Engineers Comments Regarding Surface Water Drainage

APPLICATION NO: A/37/20/DOC

Site Address: Land between Ashurst and Badger Ham Manor Way Angmering
BN16 4JQ

Description of Works: Approval of details reserved by condition imposed under ref
A/55/19/PL relating to Condition No 4 - surface water drainage

| Drawing Title  | SW Drainage Layout                 |

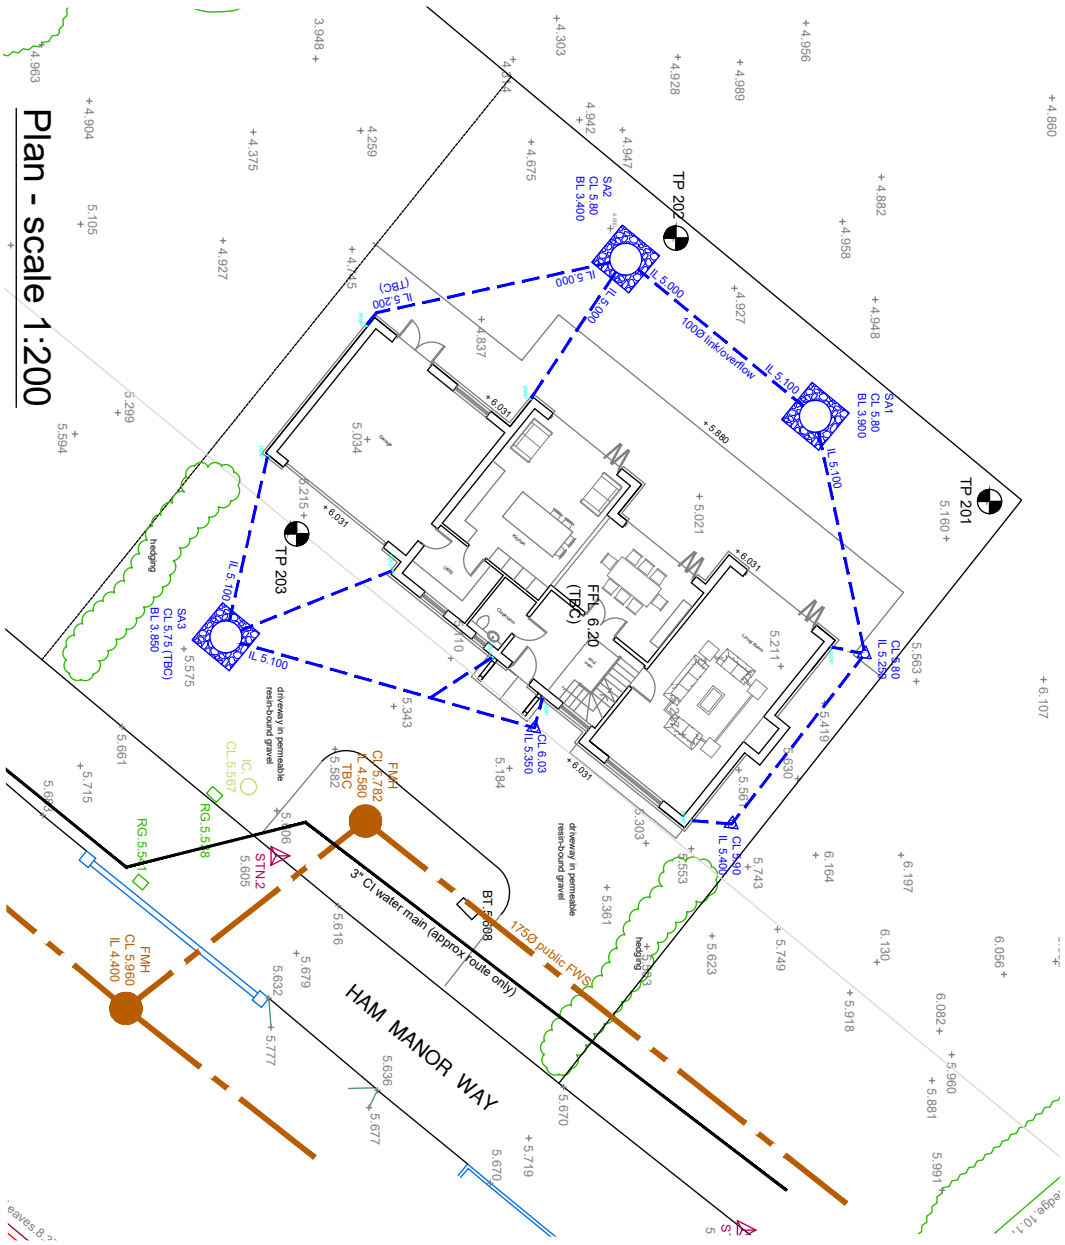
1. Soakaway no.1 near retaining wall is showing top water level (5.206) higher than the ground levels in the adjacent golf course. Perforated rings extend up to 5.000m AOD, just slightly above those ground levels, but granular surround is higher, and the link overflow pipe is set at 5.100. There is spare capacity in soakaway no.2 for when the link pipe operates. We would like to see the link pipe level dropped below the adjacent golf course ground levels, to safeguard any possibility of water finding its way out of soakaway no.1 (before water flows into no.2) i.e. through perforated rings and then into granular surround and then passing through the retaining wall (via weep holes or drains) and into the golf course.

2. Silt traps are needed upstream of soakaways. It is noted that a construction detail is included for an inspection chamber but these are not shown on the layout.

- b. Pipe bed and surrounds
 - c. Driveway
 - d. Section of retaining wall to show it's drainage
5. It appears that ground levels are only being raised around the building and not the land to the south. However, from what we can see in terms of levels, the proposed raising of ground levels is going to conflict with the flow path/storage. The applicant needs to indicate what they believe to be the flow path/storage on their drawings so we can discuss this further and ensure that the flow path is not being diverted on to neighbouring properties and that the natural storage on the site is compensated for.

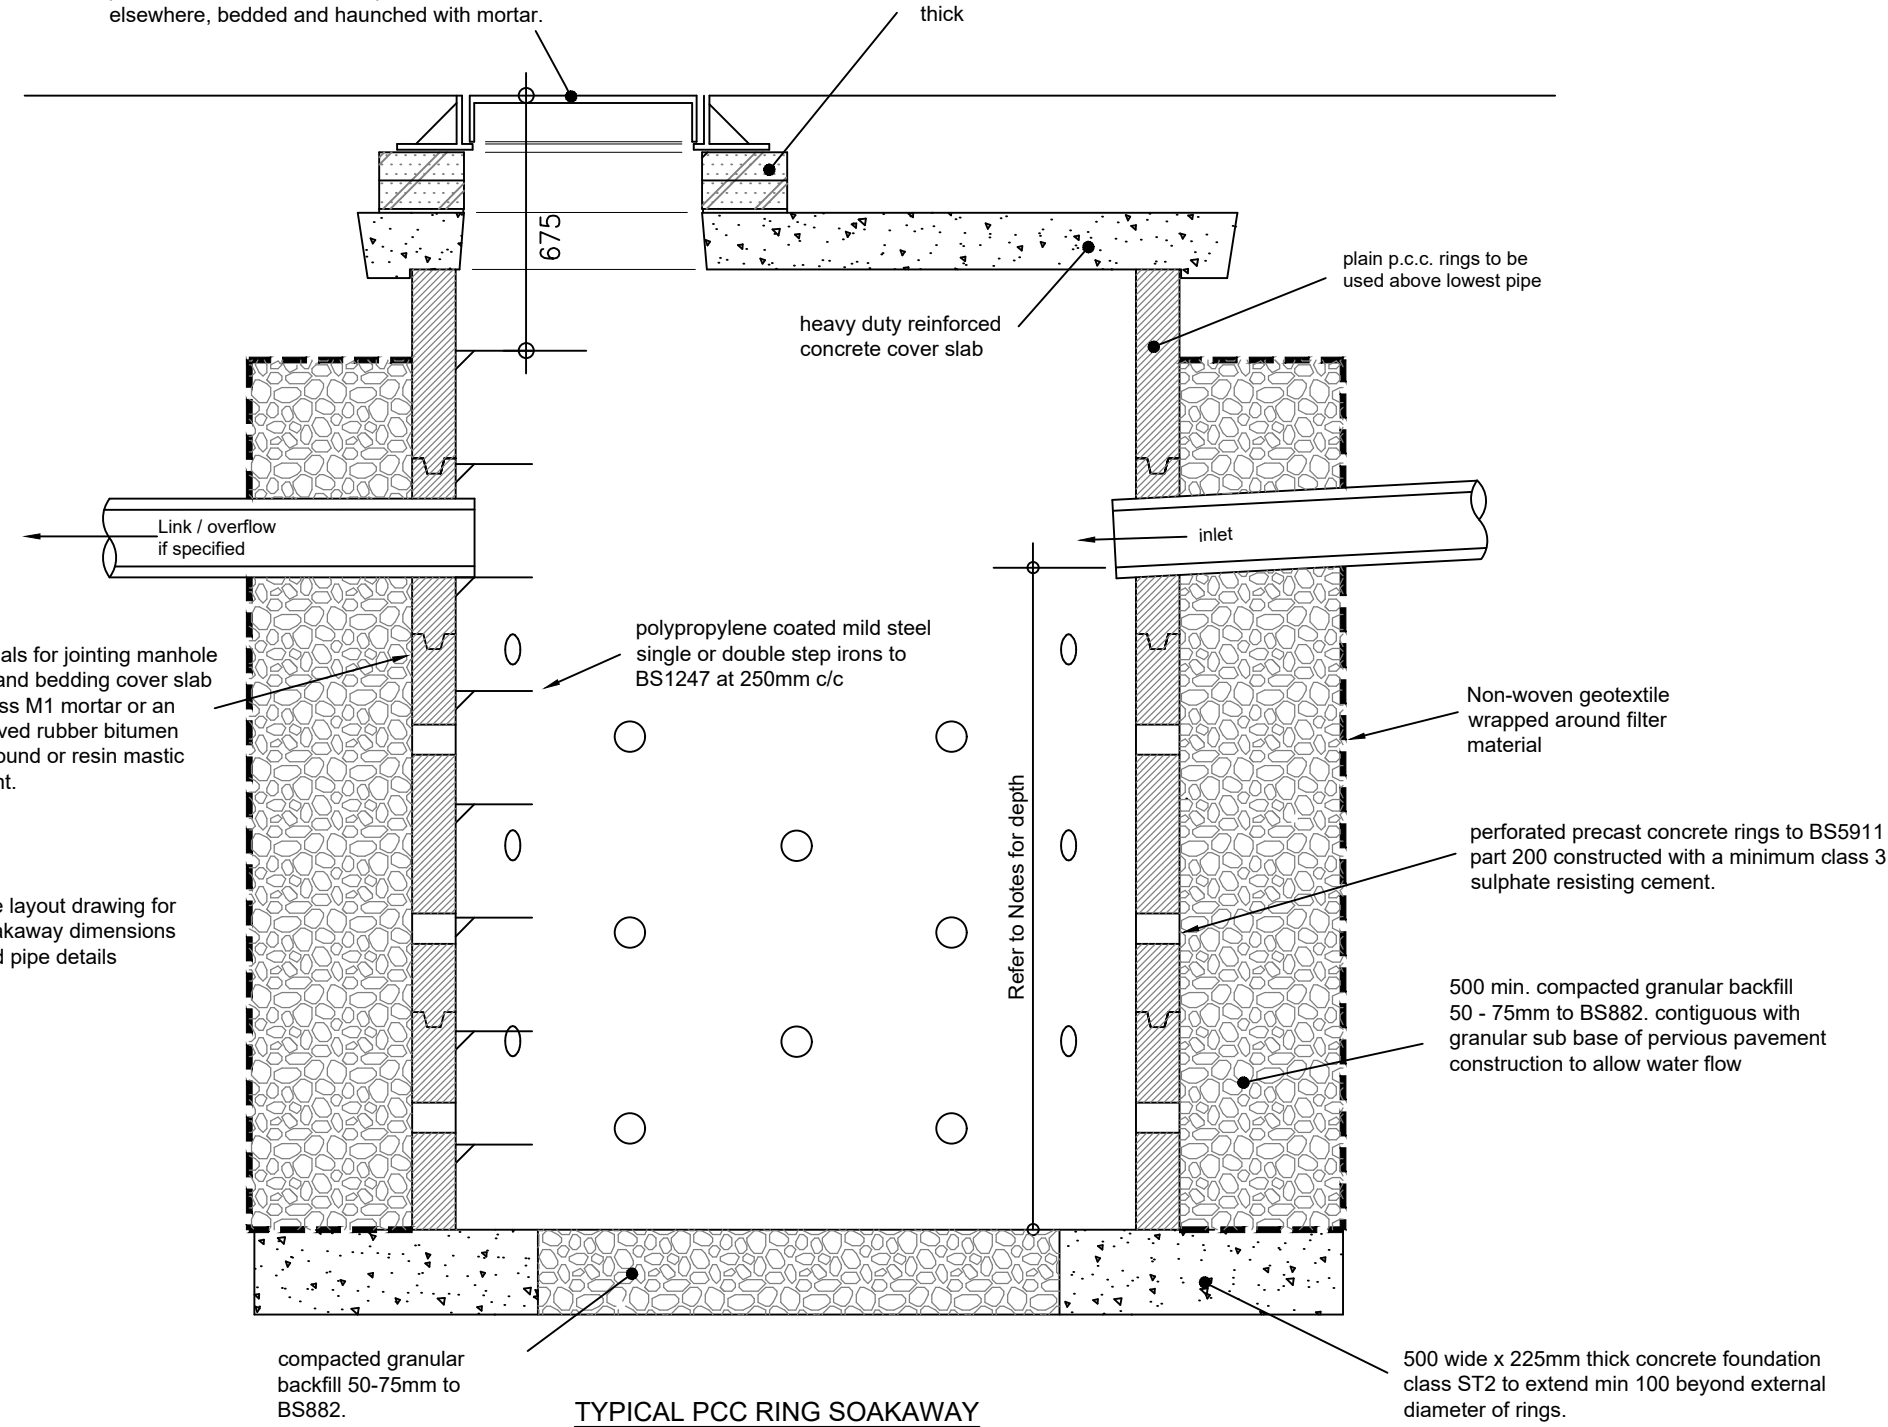
3. Driveway noted as resin bound (porous) but no calculations or construction details have been provided.
4. Construction details are required for:
 - a. Silt traps
